# Cliffe Lane, Gomersal

## Stage 1 Road Safety Audit Response Report

**PROJECT TITLE:** Cliffe Lane, Gomersal  
**REPORT TITLE:** Stage 1 Road Safety Audit Response Report  
**PROJECT REFERENCE:** 152130  
**DOCUMENT NUMBER:** 005  
**ISSUE NUMBER:** 01  
**DATE:** September 2024

Table F.2 Authorisation sheet	
Project:	Kirklees Council Planning application 2023/92966 Land to the rear of, 271 Cliffe Lane, Gomersal, Cleckheaton, BD19 4SB for Demolition of existing dwelling and erection of 87 dwellings including formation of a new access from Cliffe Lane, landscaping, public open space and all associated infrastructure and engineering works
Report Title:	Stage 1 Road Safety Audit Response Report
<b>Prepared By:</b>	
Name:	Simon Burkinshaw FHIE
Position:	Principal Engineer
Signed:	Signed copy available upon request
Organisation:	Sanderson Associates Consulting Engineers
Date:	05 September
<b>Approved By:</b>	
Name:	Karen Smith FIHE
Position:	Associate Director
Signed:	Signed copy available upon request
Organisation:	Sanderson Associates Consulting Engineers
Date:	05 September

Copy Of Phoenix 2 Duo Recycler (P2-15W with Elite 6x4 chassis)
 Overall Length 11.850m
 Overall Width 3.750m
 Overall Body Height 2.530m
 Min Body Ground Clearance 0.309m
 Track Width 2.530m
 Lock to lock time 4.00s
 Wall to Wall Turning Radius 11.035m

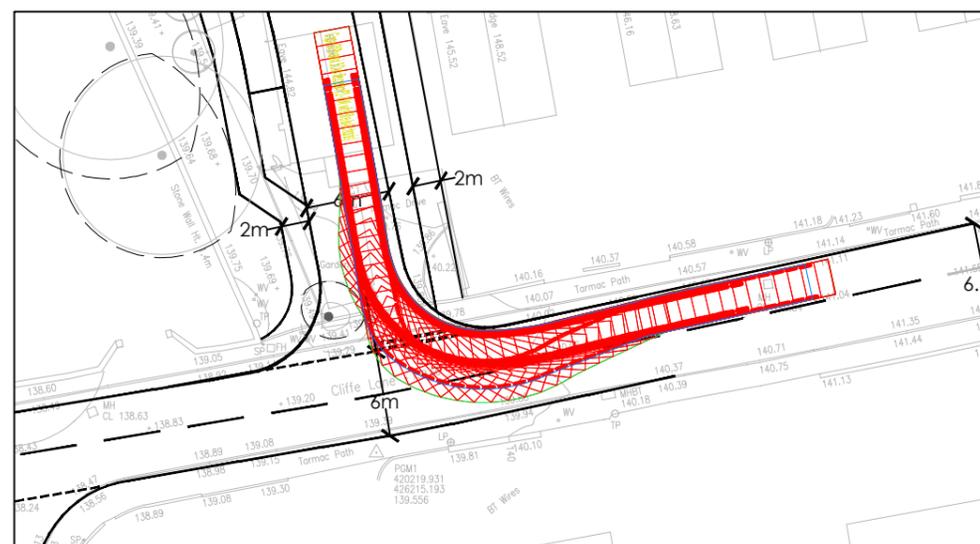
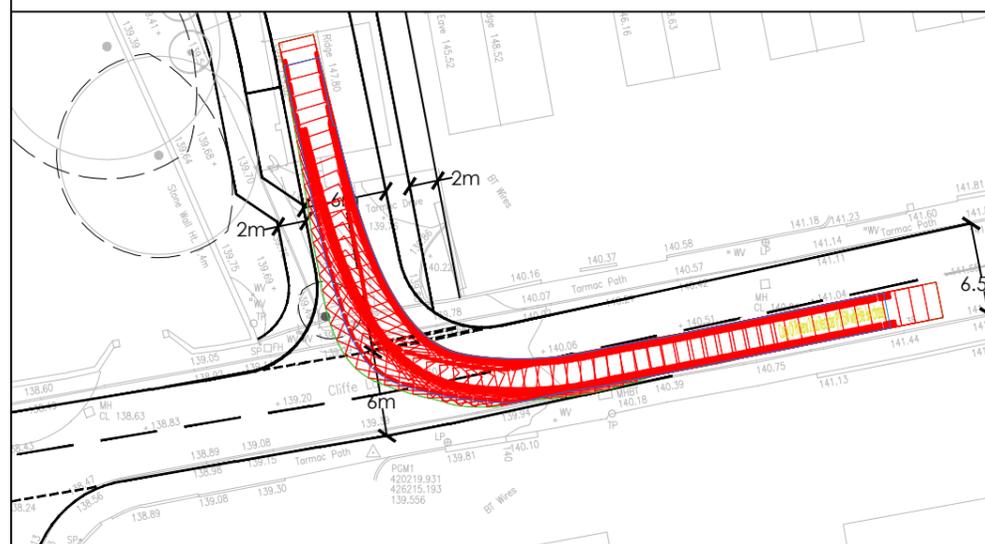
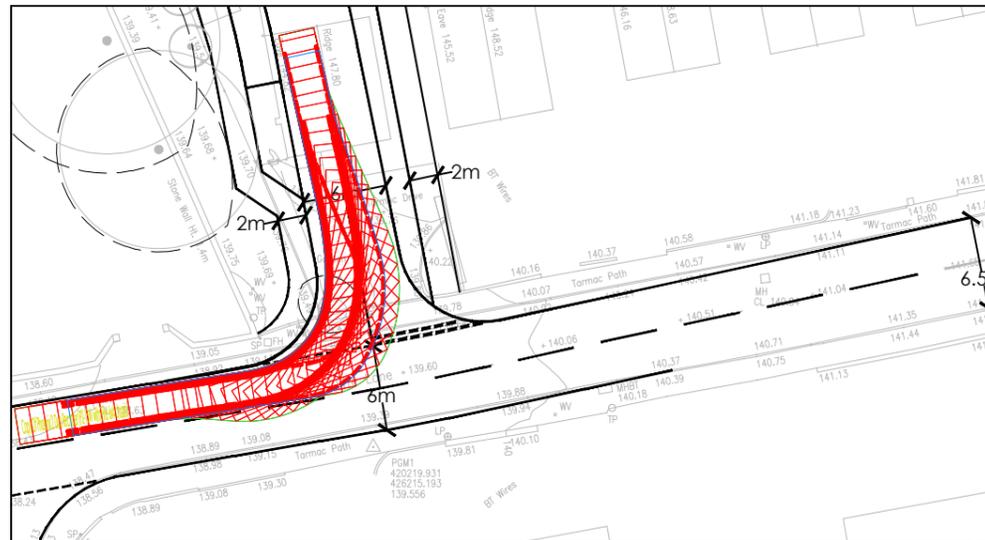
Table F.4 Road Safety Audit Decision Log				
RSA Problem	RSA Recommendation	Design Organisation Response	Overseeing Organisation Response	Agreed RSA Action
<p><b>Problem 2.3.1:</b>  <b>Location:</b> The new priority T-junction in Cliffe Lane (Drawing Nos. 1694-101 Rev J &amp; 152130-001 Rev A).</p> <p><b>Summary:</b> The swept path requirements of refuse vehicles turning, entering and exiting the new priority T-junction requires the vehicles' bodies to encroach into the opposing vehicular traffic lanes. This situation could result in a potential increased risk of offside to offside vehicular collisions occurring and head-on type vehicular collisions occurring, whereby vehicle occupants could sustain personal injury.</p> <p><b>Detail:</b> The scheme drawings include swept path analysis exercises for a refuse vehicle turning, entering and exiting the new priority T-junction in Cliffe Lane. It is evident from the swept path analysis exercises that in everyday operational terms, encroachment of the opposing vehicular traffic lanes will take place.</p> <p>Concern arises that the swept path requirements of refuse vehicles turning, entering and exiting the new priority T-junction could lead to a potential increased risk of offside to offside vehicular collisions occurring and head-on type vehicular collisions occurring, whereby vehicle occupants could sustain personal injury.</p>	<p>It is Recommended that junction geometry improvements should be undertaken, such that the potential collision scenarios are reduced or mitigated.</p> <p>If for whatever reasons the above recommendation cannot be adopted, then it is Recommended that approval for the current layout proposals should be sought and agreed with the Overseeing Organisation, i.e. the Local Highway Authority, Kirklees Council, via the DMRB GG 119 Road Safety Audit Response Report and Table F.4 Decision Log.</p>	<p>The Audit Team's Recommendation is not accepted.</p> <p>The access arrangement was previously proposed as part of previous application 2019/90902 and the access from Cliffe Lane was agreed by Kirklees Highways.</p> <p>The access are arrangements are provided in line with guidance contained within the Kirklees Highway Design Guide.</p> <p>It should also be noted that Manual for Streets states: <i>"The design of local roads should accommodate service vehicles without allowing their requirements to dominate the layout. On streets with low traffic</i></p>

<p><i>flows and speeds, it may be assumed that they will be able to use the full width of the carriageway to manoeuvre. Larger vehicles which are only expected to use a street infrequently, such as pantechnicons, need not be fully accommodated"</i></p>		
<p><b>Problem 2.4,1:</b>  <b>Location:</b> Locations 2 &amp; 3 - The proposed pedestrian footpaths where they join Ferrand Lane (Drawing Nos. 1694-101 Rev J &amp; 152130-003 Rev A).  <b>Summary:</b> Potential restrictions to intervisibility where the proposed pedestrian footpaths meet Ferrand Lane could lead to a potential increased risk of vehicular and pedestrian collisions occurring, whereby pedestrians could sustain personal injury.  <b>Detail:</b> The scheme drawings indicate that two new pedestrian footpaths located in the north eastern quadrant and the northern area of the proposed residential development will facilitate pedestrian access to and from Ferrand Lane.          Whilst the site visit has established the rural nature of Ferrand Lane (where only one vehicular movement was observed), there are well established field boundaries of hedgerows and trees which could impact upon the intervisibility between vehicular traffic and pedestrians emerging into Ferrand Lane from the proposed footpaths.</p>	<p>It is Recommended that suitable and adequate intervisibility splays should be provided at both Locations, which may require the complete removal of the existing field boundaries comprising hedgerows and trees.</p>	<p>The Audit Team's Recommendation is accepted.          It should be noted that the existing access track (Ferrand Lane) is listed as a public footpath (ref SPE/56/10)          Both pedestrian access points are to be provided at existing field access locations.          Details of the level of pedestrian visibility to be provided and the extent of landscaping to be removed will be agreed at detailed design stage.</p>
